Peartree Hill Solar Farm

Change Application Consultation Report

Application Document Ref: EN010157/APP/8.17

October 2025

Figure 1.2: Land Areas and Cable Routes Plan with Field Numbering System

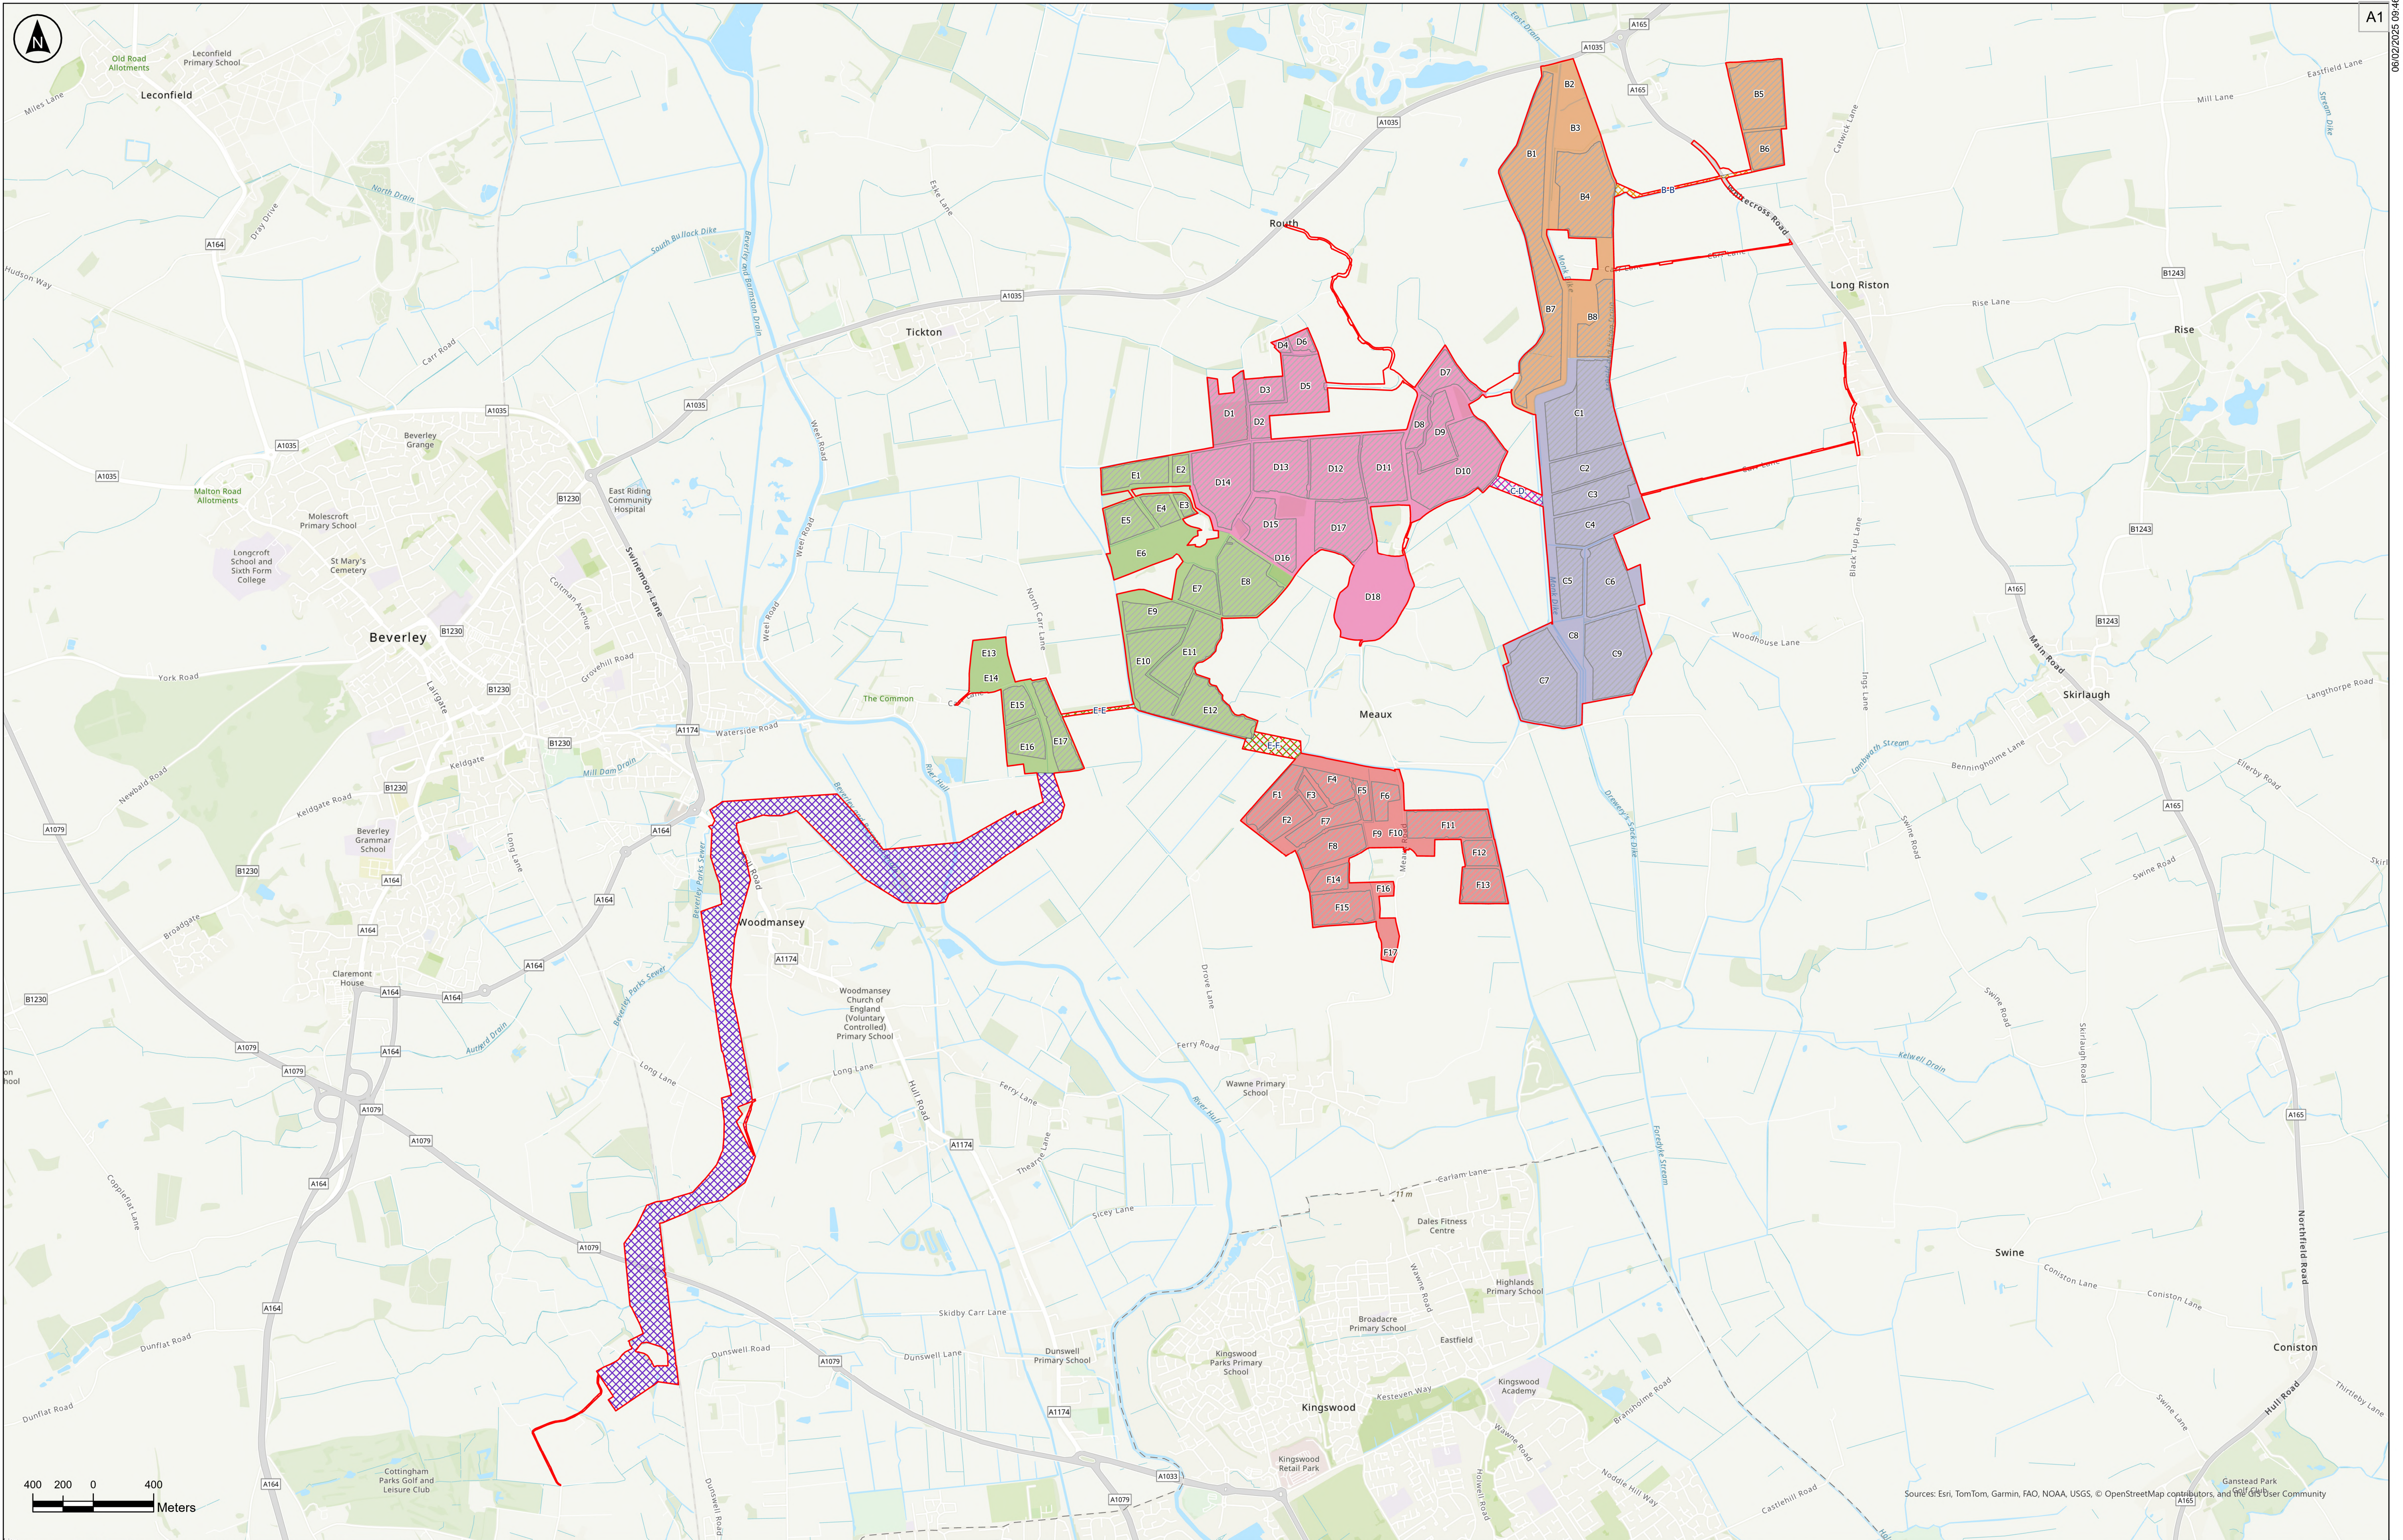
3	Beverley and North	Field E6/E7/E8	The Board maintained watercourse known as Meaux and West Drain, also	As set out in the Outline Landscape and Ecological Management Plan

Holderness Internal Drainage Board		<p>known as “Turnbull Dike”, runs along the northern edge of Field E9 and the southern boundary of fields E7 and E8.</p> <p>The Board does not anticipate the installation of this section of post and wire fencing will interfere with the Board’s maintenance activities.</p> <p>However, the Board would reiterate its position that 9 metres from the top of the embankment should be kept wholly clear of any new buildings, structures, solar panels, fences, walls, planting, or hardstanding. This is to ensure that the Board has sufficient access to the watercourse to conduct maintenance works. In addition, the Board want to ensure that there is nothing installed that will destabilise the embankments of the watercourse.</p>	<p>(LEMP) [EN010157/APP/7.5 Revision 8] which is secured by Requirement 9 of the Draft DCO [EN010157/APP/3.1 Revision 8], the design of the Proposed Development includes a minimum 10m offset from all watercourses (other than locations where crossings are required to be installed or where existing crossing points or culverts require upgrading).</p> <p>To the extent that any work was proposed in, on, under, over or within 9m from bank top of a watercourse under the control of the Board, this would need to be agreed with the Board pursuant to the protective provisions set out in Schedule 12, Part 3 (For the protection of the drainage authorities) of the Draft Development DCO [EN010157/APP/3.1 Revision 8].</p>

4	Beverley and North Holderness Internal Drainage Board	Field B2/B3	<p>The Board notes that the applicant intends to place a post and wire fence around the perimeter of Field B2 which has been proposed as a biodiversity mitigation area. The Board would make the applicant aware that the Riston Pumping Station is situated in the southwestern corner of Field B2, and the Board maintained watercourse</p>	<p>As set out and secured in the Outline LEMP [EN010157/APP/7.5 Revision 8], the design of the Proposed Development includes a minimum 10m offset from all watercourses (other than locations where crossings are required to be installed or where existing crossing points or culverts require upgrading).</p>

5	Beverley and North Holderness Internal Drainage Board	Fields B8/B9	<p>The Board maintained watercourse known as Arnold and Riston Drain runs along the eastern boundary of Field B8, and the Board maintained watercourse known as Riston Drain runs along the southern and western boundary of Field B8. The proposed post and wire fencing will run alongside these watercourses. The proposed additional post and wire fencing along the western boundary of Field F9 will run alongside the Board maintained watercourse known as North Wray.</p> <p>For any Board maintained watercourse, the Board would ask that 9 metres from the top of the embankment is kept wholly clear of hardstanding, fencing, solar panels, and planting etc. For any ordinary watercourses within the Board's district, 3 metres should be kept wholly clear of any hardstanding, planting or fencing, and 9 metres clear of solar panels.</p>	<p>As set out in the Outline LEMP [EN010157/APP/7.5 Revision 8] which is secured by Requirement 9 of the Draft Development Consent Order [EN010157/APP/3.1 Revision 8], the design of the Proposed Development includes a minimum 10m offset from all watercourses (other than locations where crossings are required to be installed or where existing crossing points or culverts require upgrading).</p> <p>To the extent that any work was proposed in, on, under, over or within 9m from bank top of a watercourse under the control of the Board, this would need to be agreed with the Board pursuant to the protective provisions set out in Schedule 12, Part 3 (For the protection of the drainage authorities) of the Draft DCO [EN010157/APP/3.1 Revision 8].</p>

6	Beverley and North Holderness Internal Drainage Board	Field B16	<p>The Board maintained watercourse known as Routh and Meaux Drain, also known as Caresticks, runs through the middle and along the western boundary of Field D16. Whilst the proposed new fencing on the eastern boundary of D16</p>	<p>As set out in the Outline LEMP [EN010157/APP/7.5 Revision 8] which is secured by Requirement 9 of the Draft DCO [EN010157/APP/3.1 Revision 8], the design of the Proposed Development includes a minimum 10m offset from all</p>

<p>known as the Arnold and Riston Drain also runs along the southern boundary of field B2. The Board would ask that 9 metres is kept wholly clear of solar panels, planting, fencing, hardstanding etc. from the top of the embankment as per the Board's requirements for maintenance activities.</p> <p>There is an existing access track within Fields B2/3 which runs along the Arnold and Riston Drain up to the pumping station. The Board would ask that this existing access is kept in place, or the applicant provides an appropriate alternative access to the watercourse and pumping station which is suitable for heavy tracked machinery in order for maintenance activities to be carried out.</p>	<p>To the extent that any work was proposed in, on, under, over or within 9m from bank top of a watercourse under the control of the Board, this would need to be agreed with the Board pursuant to the protective provisions set out in Schedule 12, Part 3 (For the protection of the drainage authorities) of the Draft DCO [EN010157/APP/3.1 Revision 8].</p> <p>The Applicant notes the Board's comments regarding permeability of access tracks. Internal access track design, including materials, will be confirmed as part of the detailed design stage and submitted to East Riding of Yorkshire Council for approval as part of Requirement 3 of the Draft DCO [EN010157/APP/3.1 Revision 8]. As set out in the Outline Construction Environmental Management Plan [EN010157/APP/7.2 Revision 6] which is secured by Requirement 4 of the Draft Development Consent Order [EN010157/APP/3.1 Revision 8], if Type 1 material is used for surfacing of access tracks, the Applicant will submit a drainage strategy for the relevant works to the Board. The Applicant will continue to liaise with the Board on this matter.</p>

should not interfere with the Board's activities, the Board would reiterate the applicant's previously agreed commitment to leave 9 metres clear of solar panels from the top of the embankment of any watercourse within the Board's district.	watercourses (other than locations where crossings are required to be installed or where existing crossing points or culverts require upgrading). To the extent that any work was proposed in, on, under, over or within 9m from bank top of a watercourse under the control of the Board, this would need to be agreed with the Board pursuant to the protective provisions set out in Schedule 12, Part 3 (For the protection of the drainage authorities) of the Draft DCO [EN010157/APP/3.1 Revision 8] .
Mining Remediation Authority (Coal Authority)				
7	Mining Remediation Authority (Coal Authority)	All changes	The site to which this submission relates is not located within the defined coalfield. On this basis we have no specific comment to make.	The Applicant notes this comment.

Figure 14.3: Public Rights of Way and Long Distance Paths Within and Adjacent to the Proposed Development

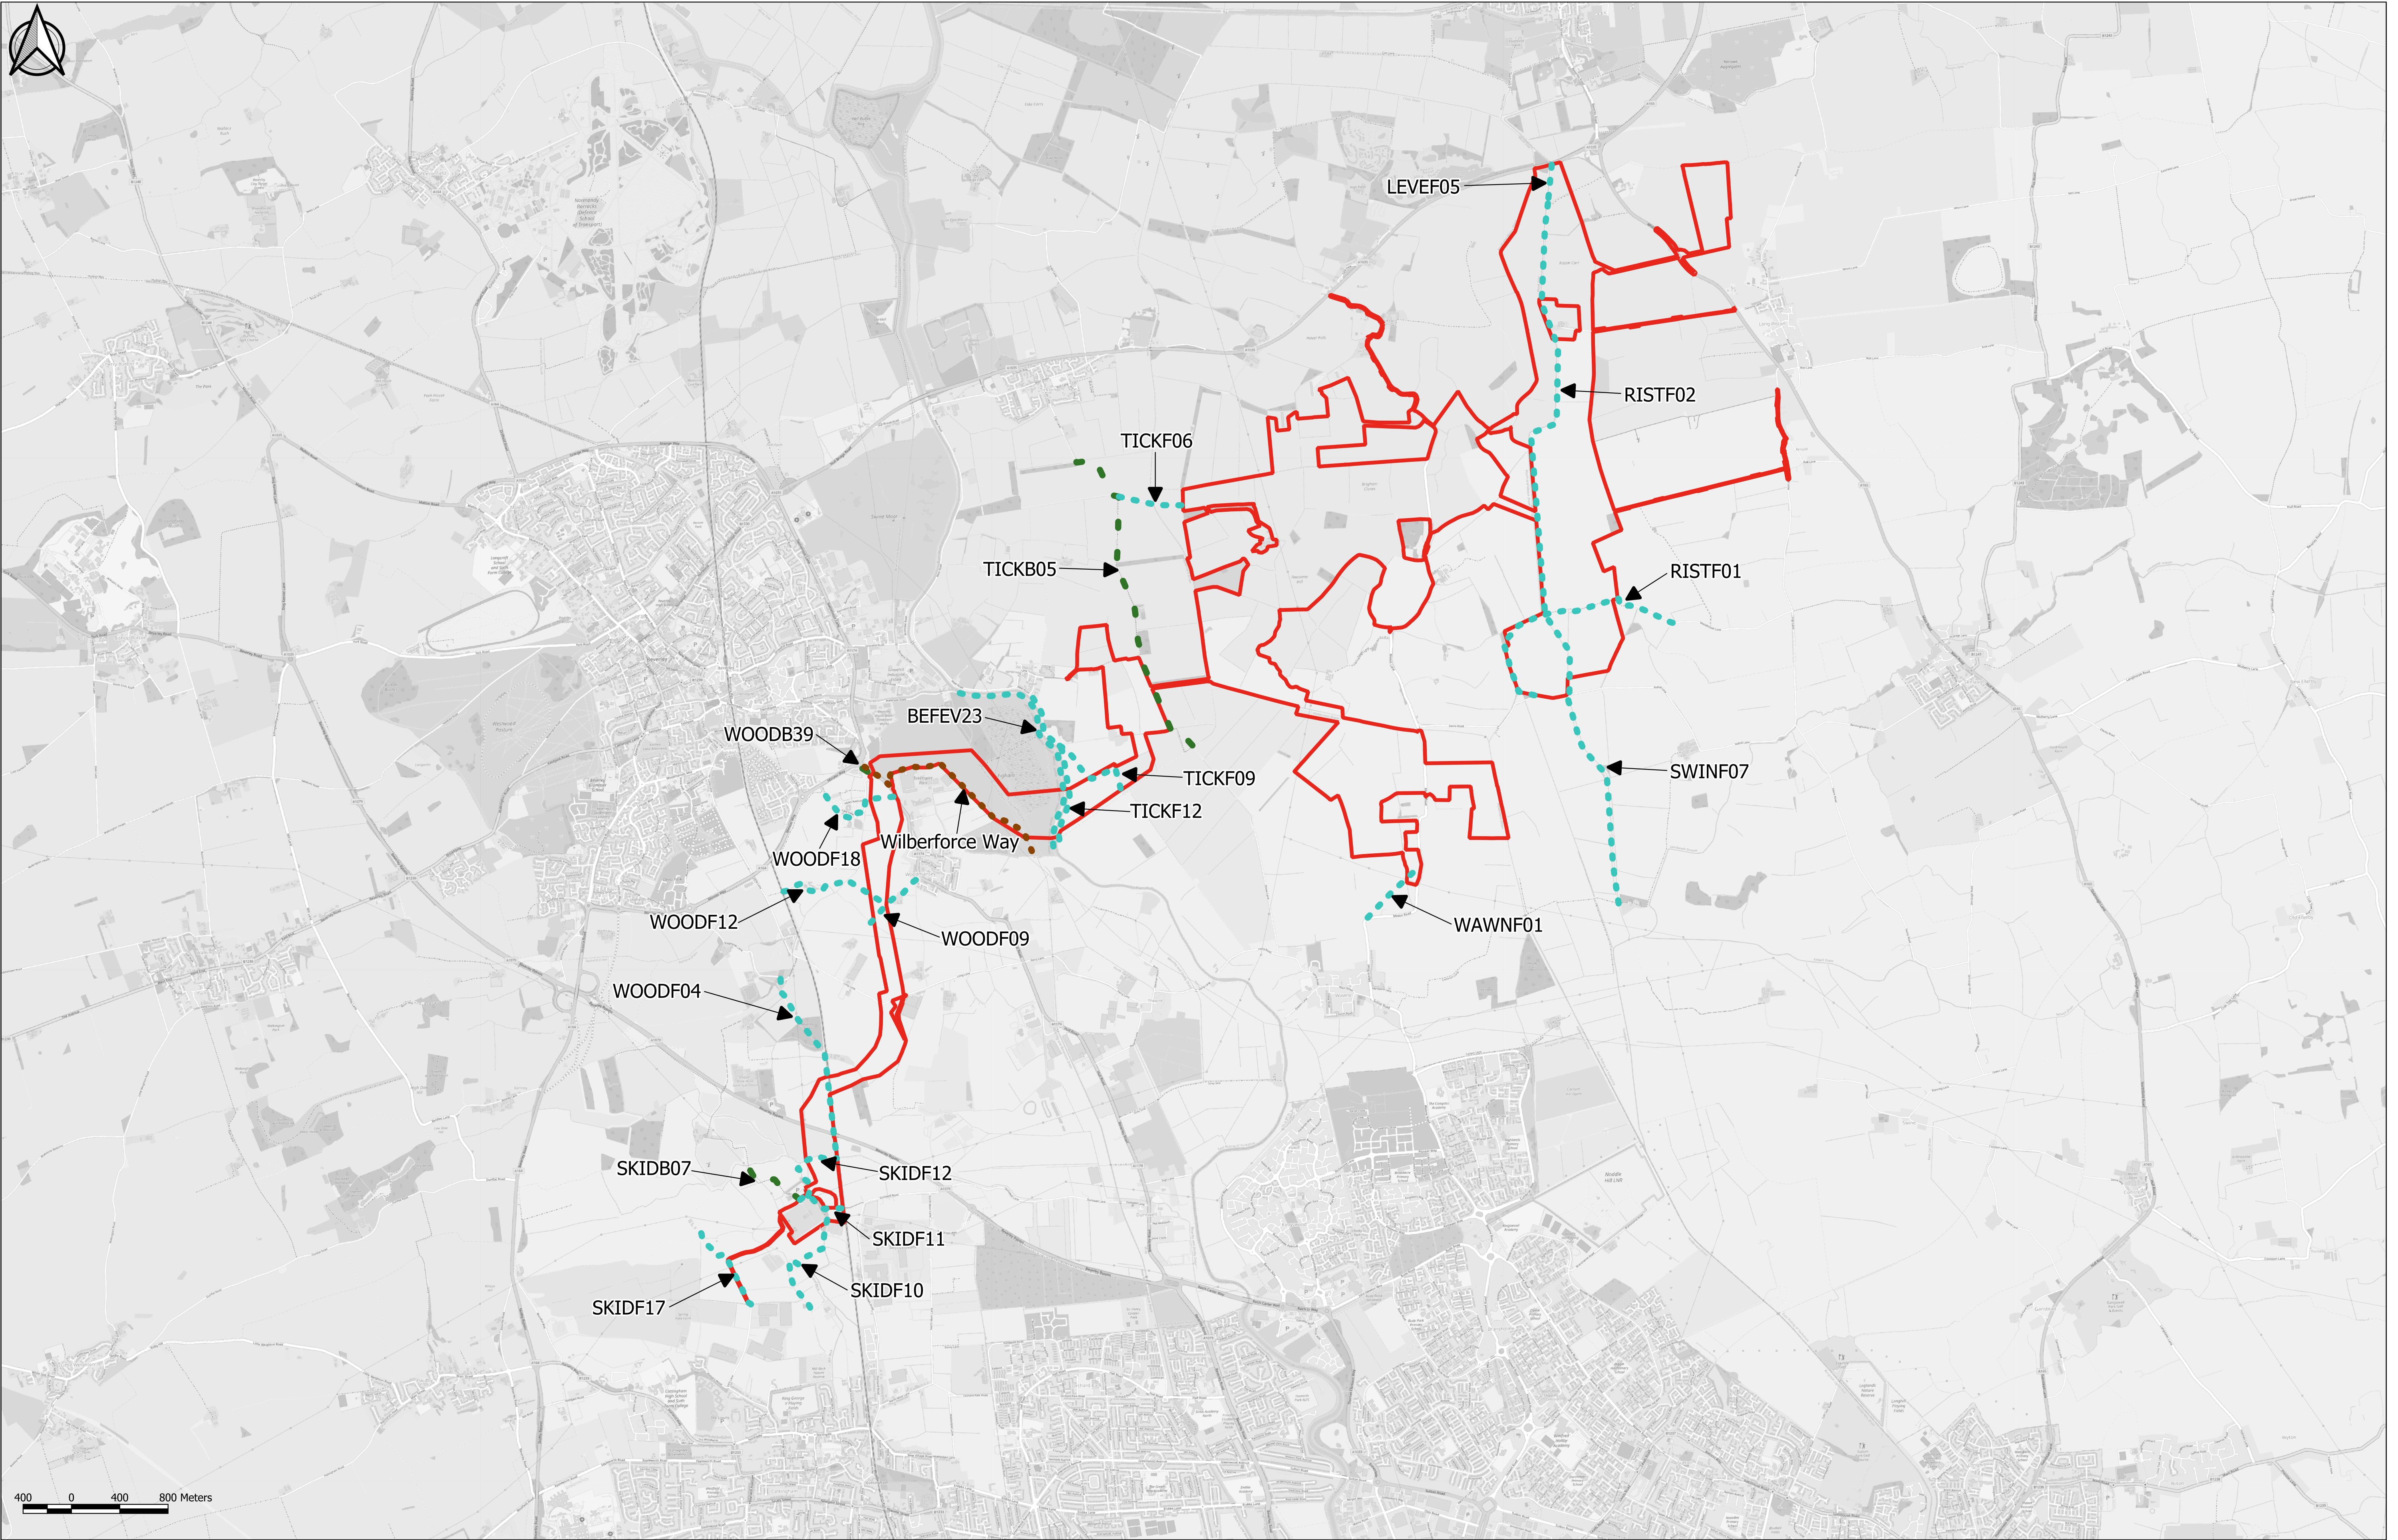
25	JLAF	All changes	3. The loss of circularity arising from the proposed changes to the permitted paths is regrettable and likely to dissuade some use of the paths. However, the essential	While the proposed changes would see the removal of some permissive paths, they also include the addition of others to retain connectivity across the Site. If

26	JLAF	All changes	<p>5. Whilst ERoY&KuHJLAF does not object to the proposed changes to the permissive path provision, we do consider that the changes represent a reduction in the only countryside access enhancements currently being offered within the project proposals (eg. reduction in length, some loss of circular nature, additional wire fencing), and they would</p>	<p>While the proposed changes would see the removal of some permissive paths, they also include the addition of others to retain connectivity across the Site. If progressed, the proposed changes would result in an overall reduction in permissive path provision of approximately 800m but there would remain a considerable network of</p>

<p>connection of the permitted paths with pre-existing PRow appears to have been retained.</p> <p>4. ERoY&KuHJLAF considers it essential to alert prospective users of the permissive paths to their non-circular or cul-de-sac nature by siting weather-proof information boards at the entry points. This will (a) alert users to the permissive paths (b) describe their length and location and (c) in the case of cul-de-sac paths, minimise disappointment and/or annoyance from users reaching the terminus and having to double back.</p>	<p>progressed, the proposed changes would result in an overall reduction in permissive path provision of approximately 800m but there would remain a considerable network of approximately 11.8km of permissive paths to be bought forward as part of the Proposed Development. The Applicant confirms that connectivity with existing PRow would be retained.</p> <p>As set out in the Outline LEMP [EN010157/APP/7.5 Revision 8] which is secured by Requirement 9 of the Draft DCO [EN010157/APP/3.1 Revision 8], the waymarking of permissive paths is yet to be determined, but the Applicant would explore options in consultation with the Community Liaison Group, which will be established for the duration of the construction period.</p>

therefore be a downgrade on the initial permissive access proposals. The aesthetic of access along the permissive paths will be diminished by the proximity of security fencing and the ranks of solar panels.	<p>approximately 11.8km of permissive paths to be bought forward as part of the Proposed Development. The Applicant confirms that connectivity with existing PRow would be retained.</p> <p>The mitigation area fencing will be low profile (up to 1m in height) post and wire fencing. Therefore, no significant landscape and visual effects are anticipated as a result of the proposed changes.</p>
27	JLAF	All changes	6. Given the size, scale and lifespan of the solar farm development, and the number of public rights of way within the development area, ERoY&KuHJLAF would still expect to see more PROW/public access enhancements included within the project provision, in addition to the permissive path proposals. The solar farm development would substantially change the landscape and the amenity value for users of the public rights of way. We would therefore draw attention to our separate correspondence relating to the Statement of Common Ground (SoCG) and in particular to our request for a one-off financial contribution to be provided to East Riding of Yorkshire Council, to effect PROW/access	<p>The updated ES Volume 1, Chapter 3: Proposed Development Description [EN010157/APP/6.1 Revision 4], which is submitted at Deadline 4, provides details of the proposals to provide a network of new permissive paths as part of the Proposed Development design. The new permissive paths aim to maintain and improve connectivity in and around the Site and in the local area through connecting to existing PRow. This is in accordance with the Overarching National Policy Statement for Energy (EN-1), which states that applicants should “take appropriate mitigation measures to address adverse effects on coastal access, National Trails, other rights of way and open</p>
